Erection of 2 no. dwellings
Land adjacent 1- Holkham Cottages Burndell Road Yapton

Thank you for your internet representation made on 26th July 2018 which has been recorded as '**an objection**' with the comments as follows:

DRAWING TITLE
Proposed Site Plan
Location and Block Plans

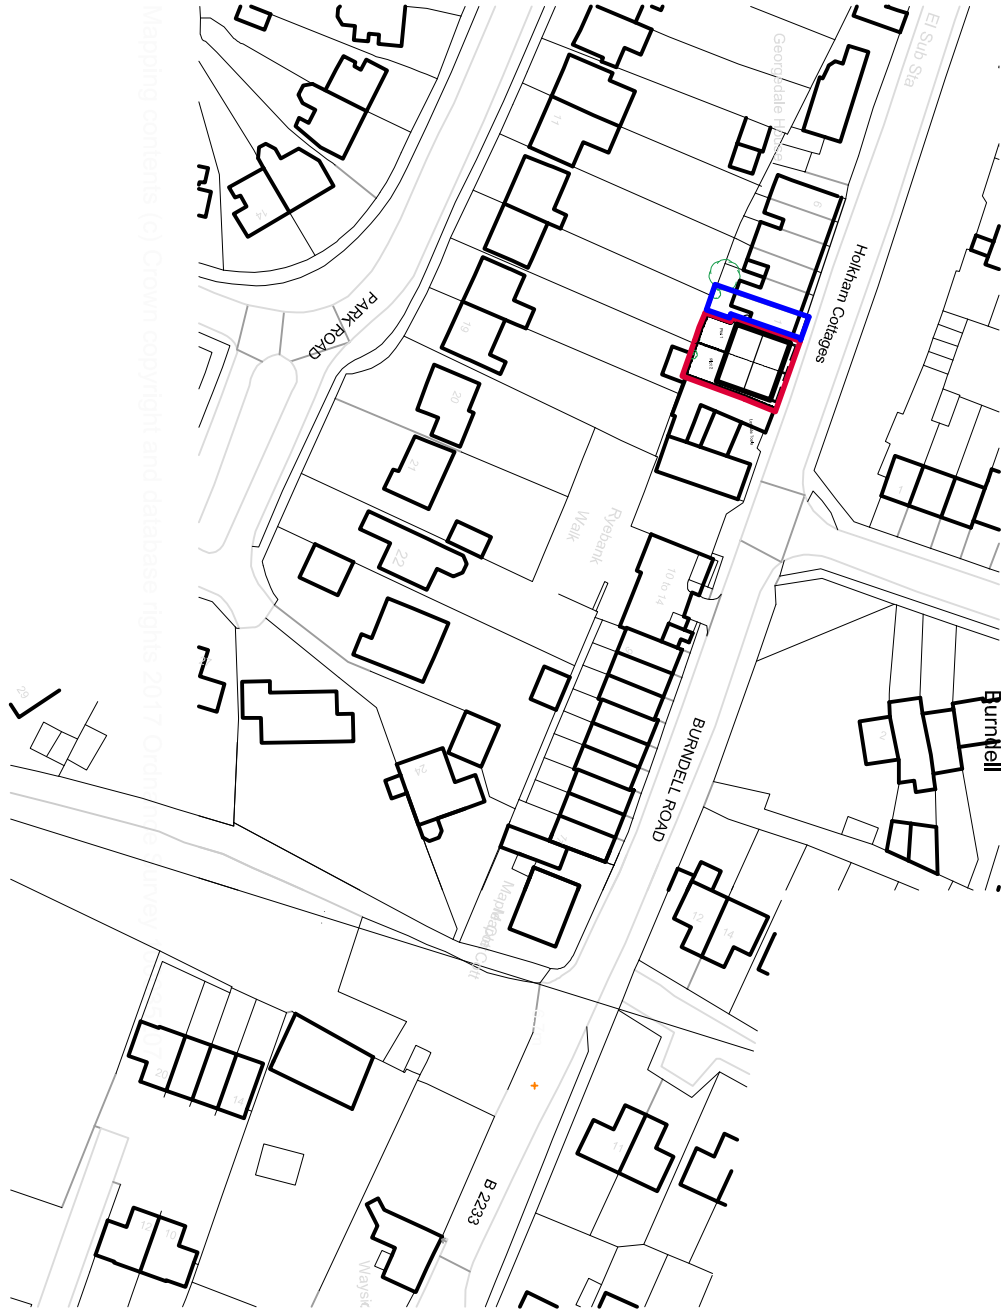
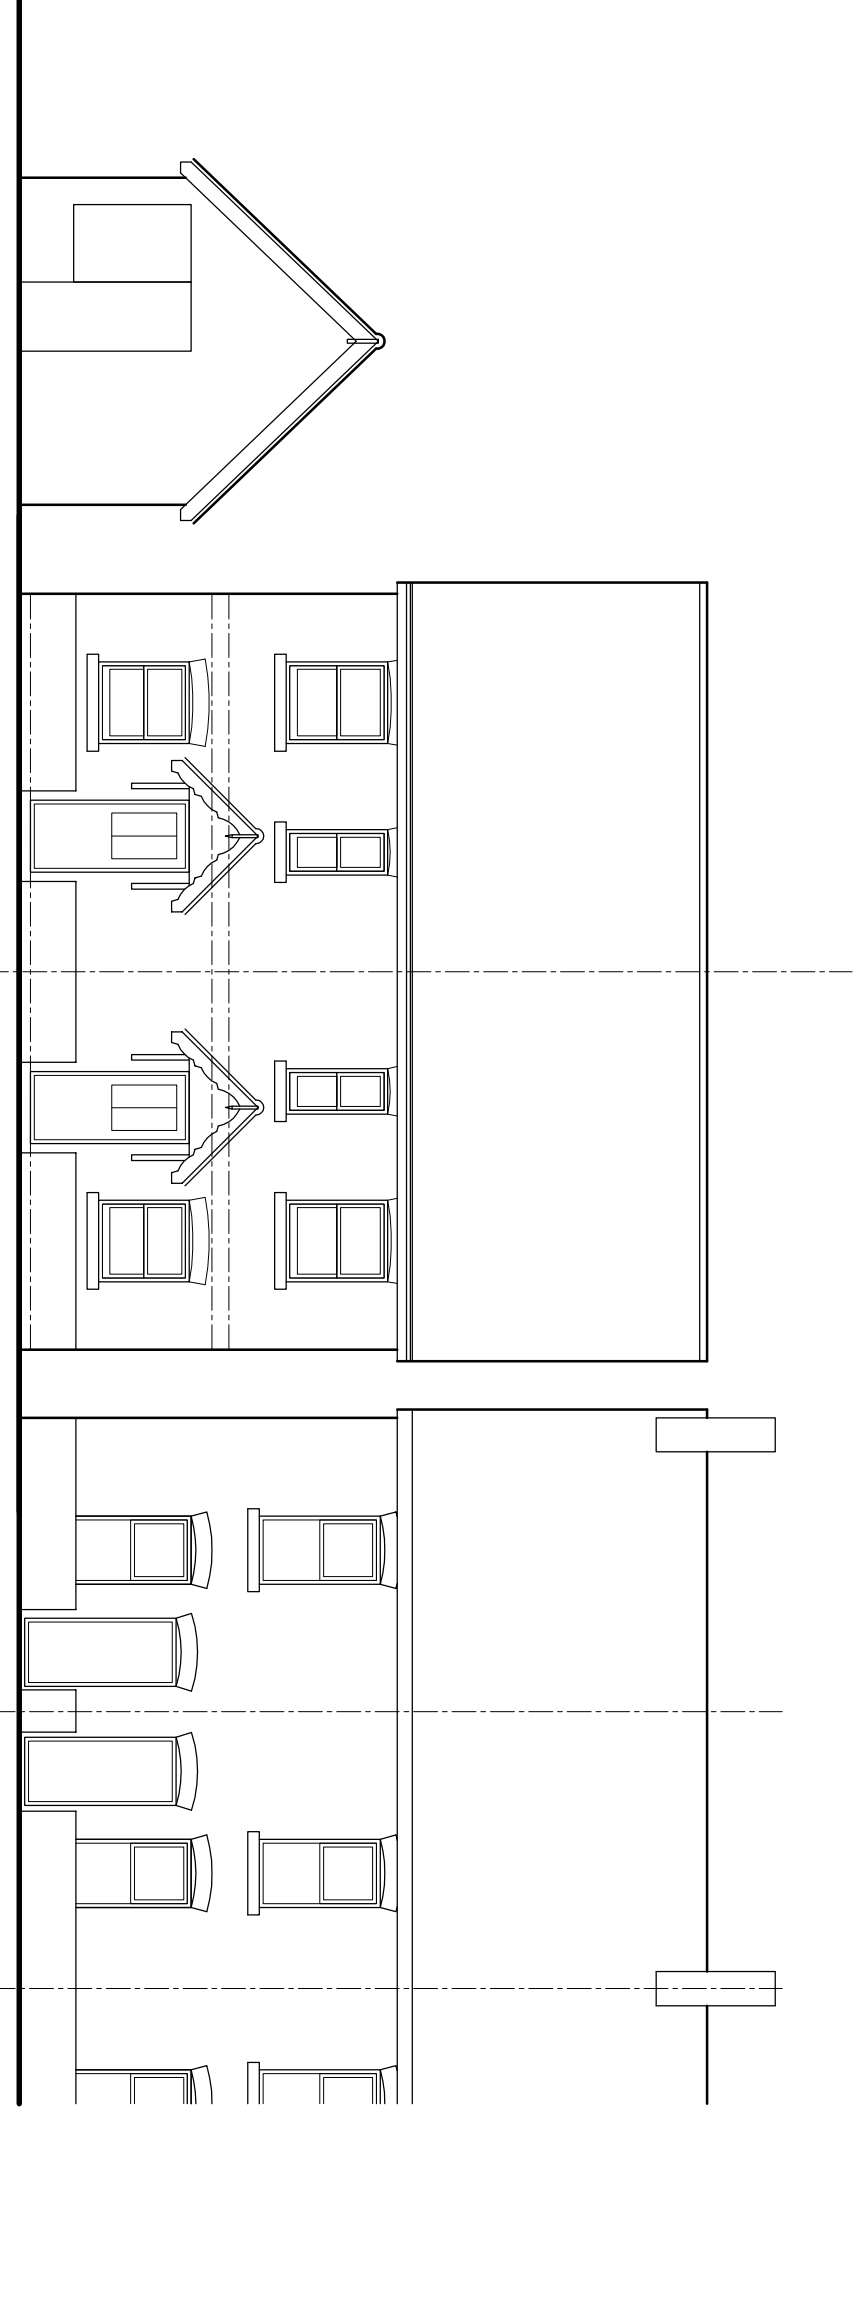
The plans outline there is a distance of 5.5m from the rear of the development to the existing boundary to the property in Park Drive. Having observed the site there is no room for a soakaway as outlined in the plans. I understand a Soakaway should not be built within 5m of the proposed development and ideally should be remote from boundaries in case the neighbour of the property in Park Drive wishes to build.

The is no provision for parking for this new development. If cars and delivery vehicles are to park outside the new properties this will cause traffic flow problems along Burndell Road and at the junction of Downview Road. This is already an issue with residents of Ryebank walk parking their vans and lorries on the Downview Estate because there is inadequate parking for larger vehicles. Therefore this development will have a negative impact on the residents in Downview Road.

During the construction of Emerald Gardens residents of Downview Road and Downview Way were unable to park due to construction workers vehicles being parked on the estate. There is no parking provision for construction workers on the proposed site, therefore they will either be causing traffic flow problems on Burndell Road or inconveniencing residents on the Downview estate. Also, there is little space for storing construction materials, therefore the developer should submit a site management plan to ensure there is minimal impact on traffic and residents in the surrounding area.
